Location of Construction: 243 Congress St		Owner:		Phone:	
Owner Address:		Leasee/Buyer's Name:		Business Name:	
Contractor Name:		Address: 400 ...		Phone: ...	
Past Use:		Proposed Use:		COST OF WORK: \$ 24,000.00 PERMIT FEE: \$ 100.00	
		FIRE DEPT. <input type="checkbox"/> Approved <input type="checkbox"/> Denied		INSPECTION: Use Group: Type:	
Proposed Project Description:		Signature:		Signature:	
		PEDESTRIAN ACTIVITIES DISTRICT (P.U.D.) Action: <input type="checkbox"/> Approved <input type="checkbox"/> Approved with Conditions <input type="checkbox"/> Denied		Signature: _____ Date: _____

REASON FOR PERMIT: Reversing floor plan - adding a chimney

DATE: 31 Dec, 97 ADDRESS: 243 Ray ST.
REASON FOR PERMIT: Amendment To permit - Add Chimneys
BUILDING OWNER: MJM ASSOCIATES
CONTRACTOR: ↓
PERMIT APPLICANT: ↑ APPROVAL: *2, *3, *6, *8, *10 ~~DENIED~~
USE GROUP R-3 BOCA 1996 CONSTRUCTION TYPE 513

Amended Plan  
29 S Ray St. Portland.

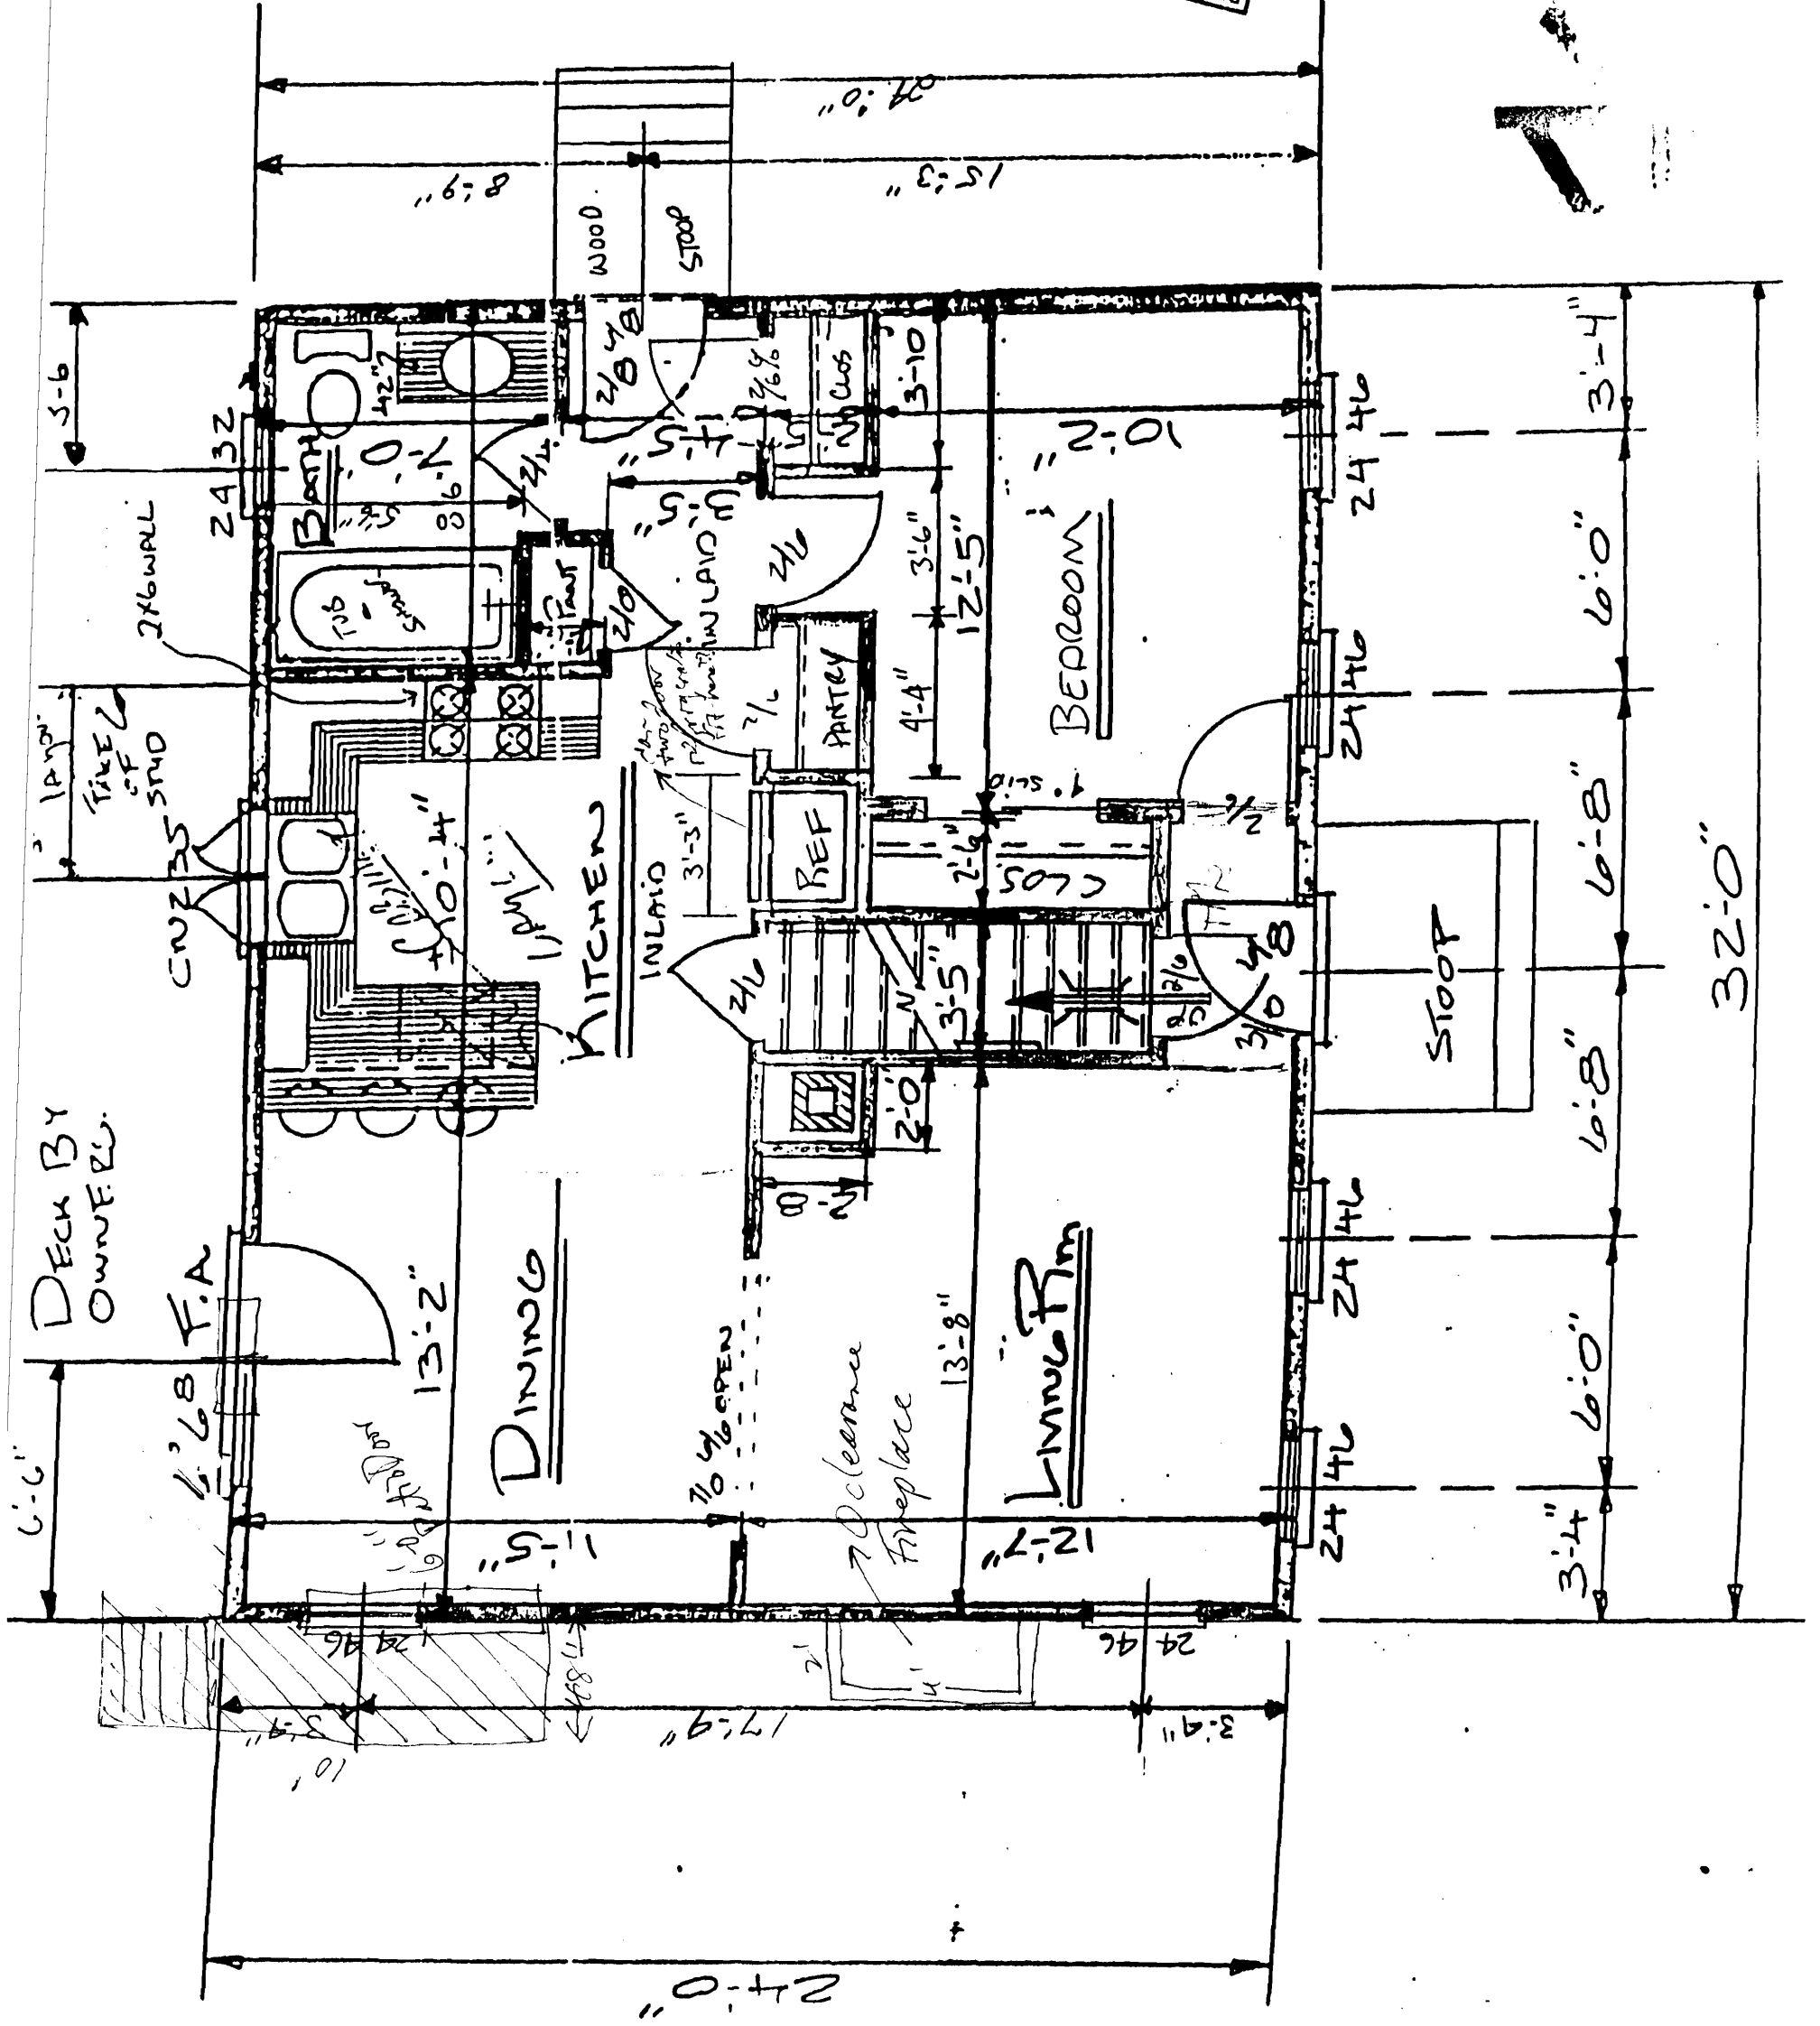
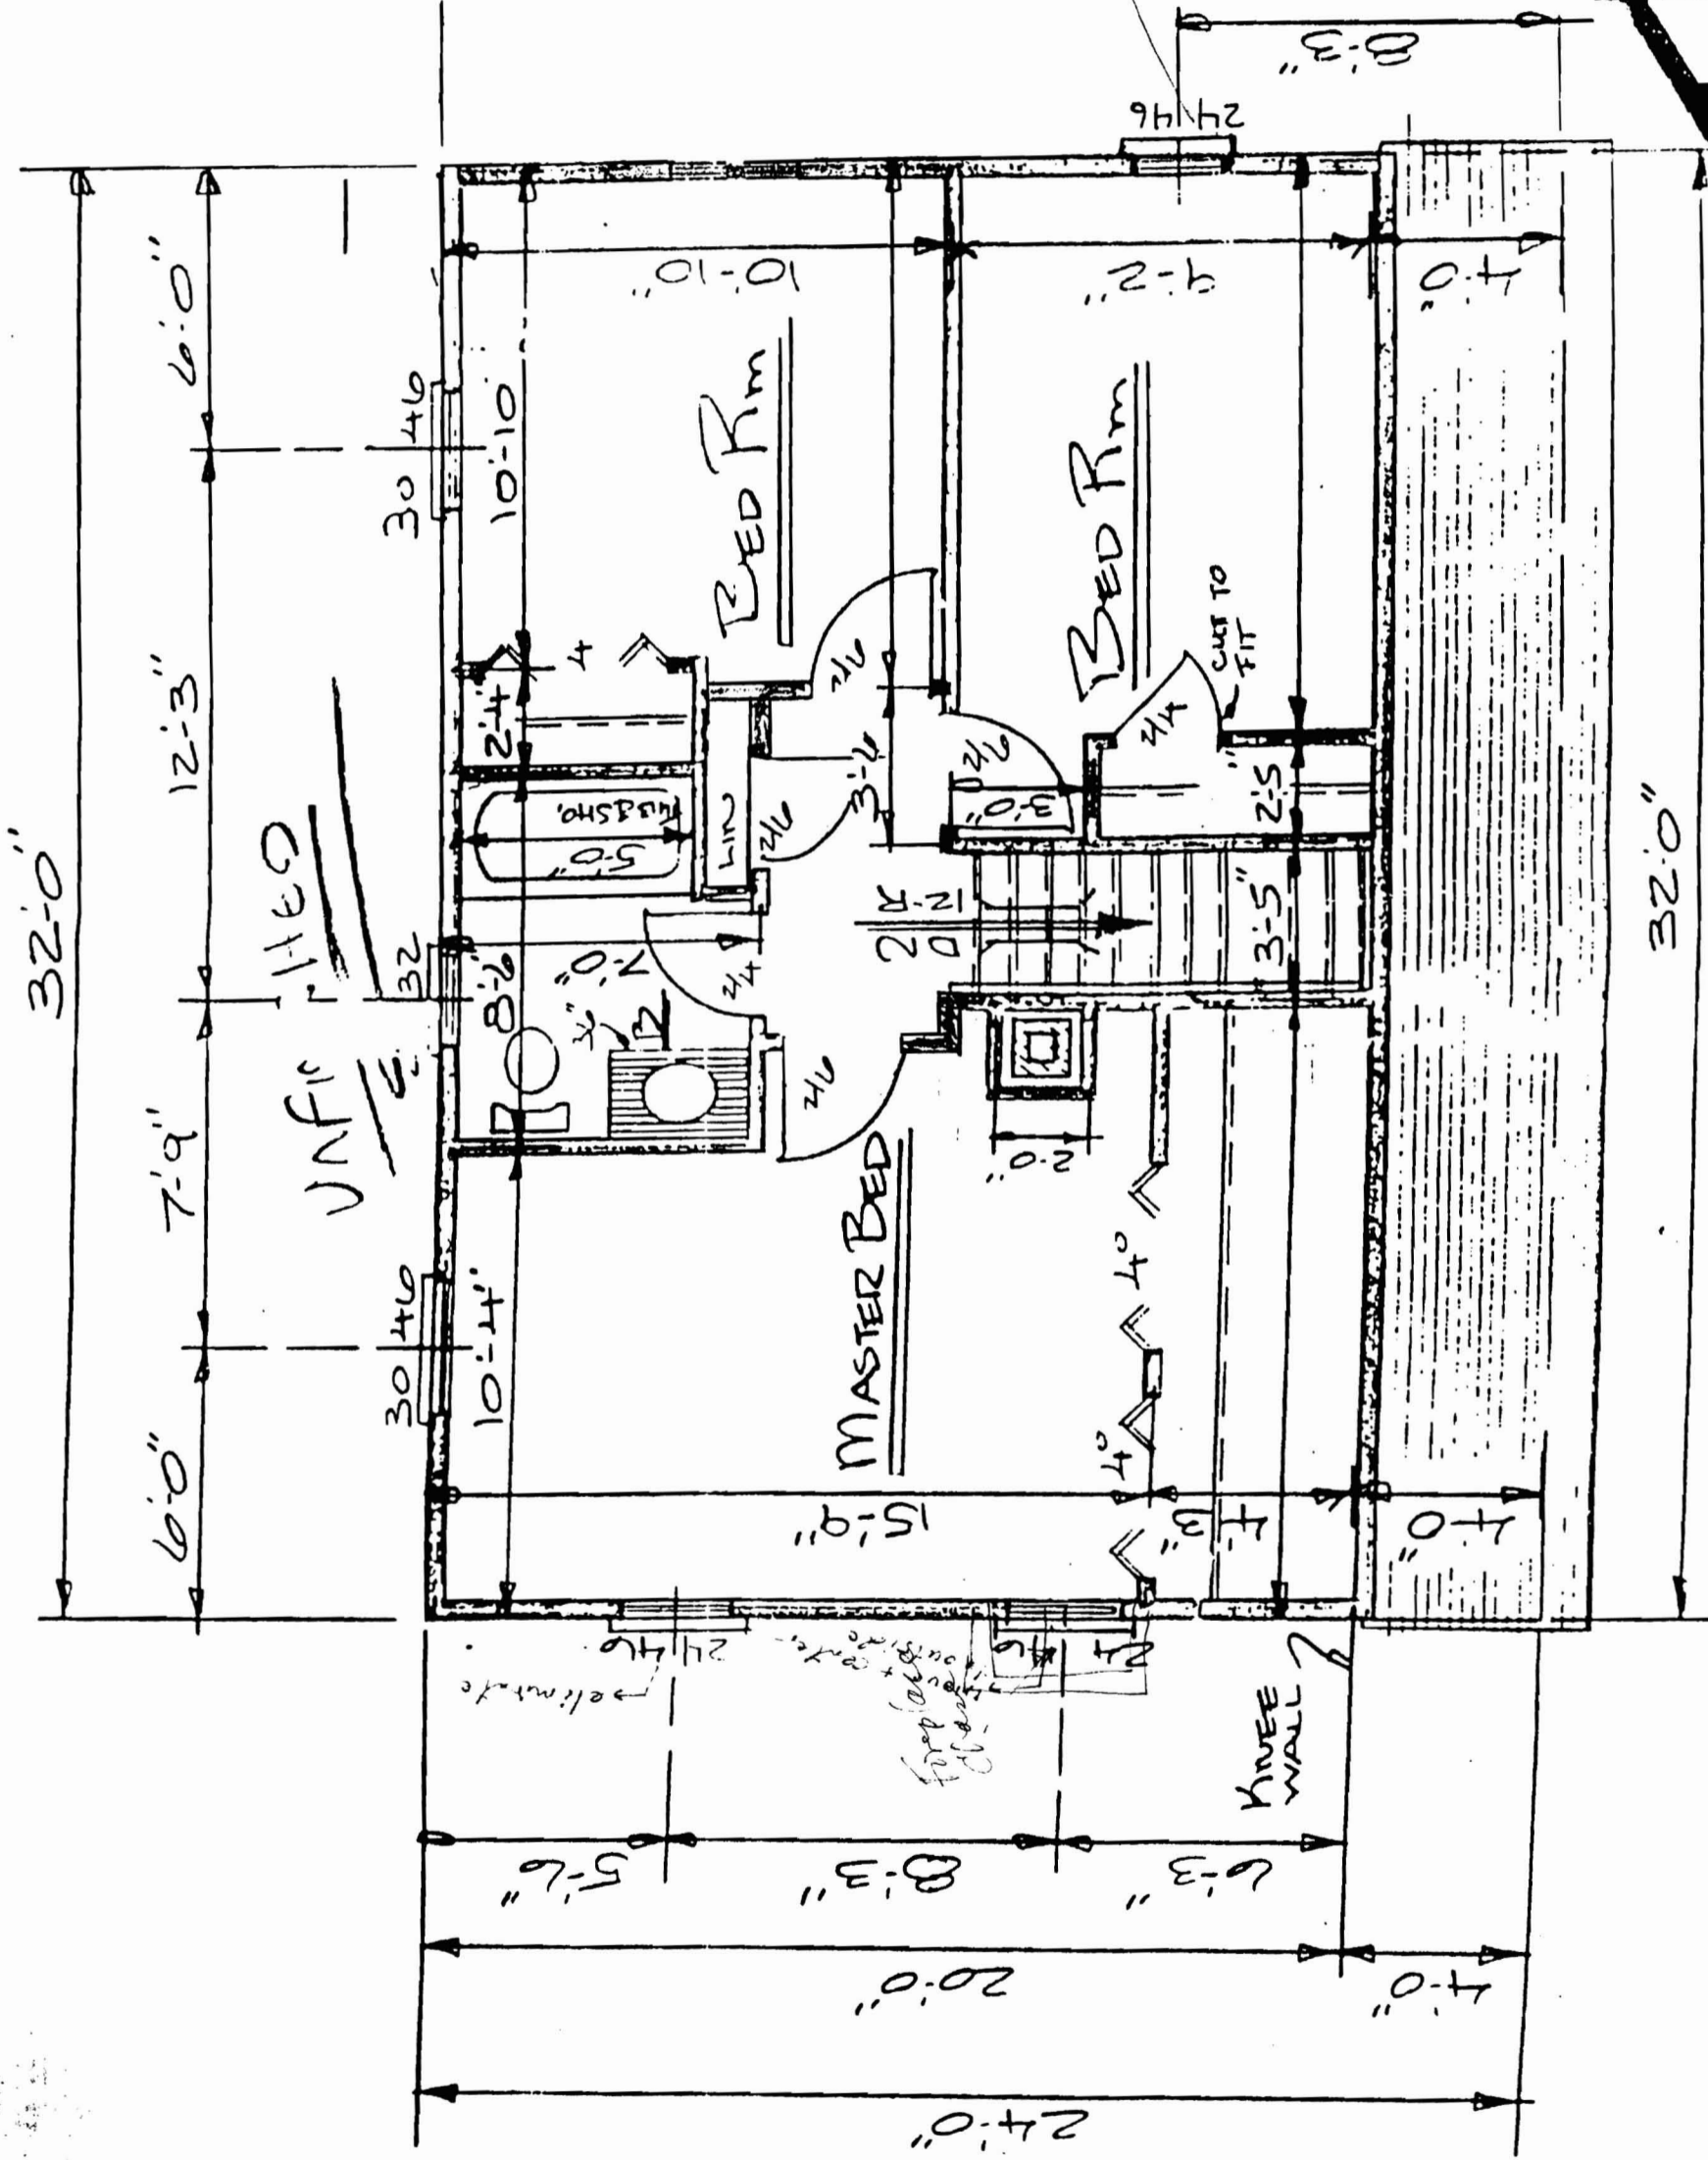
7. Separate permits shall be required for any signage.
8. Separate permits shall be required for future decks and/or garage. -shed, pool
9. Other requirements of condition the chimney shall not extend

more than two feet into any required setback

~~31.~~ Your submitted application and plan did not show any information
on the fireplace or chimney. This information must be submitted
and approved before work begins on these items.
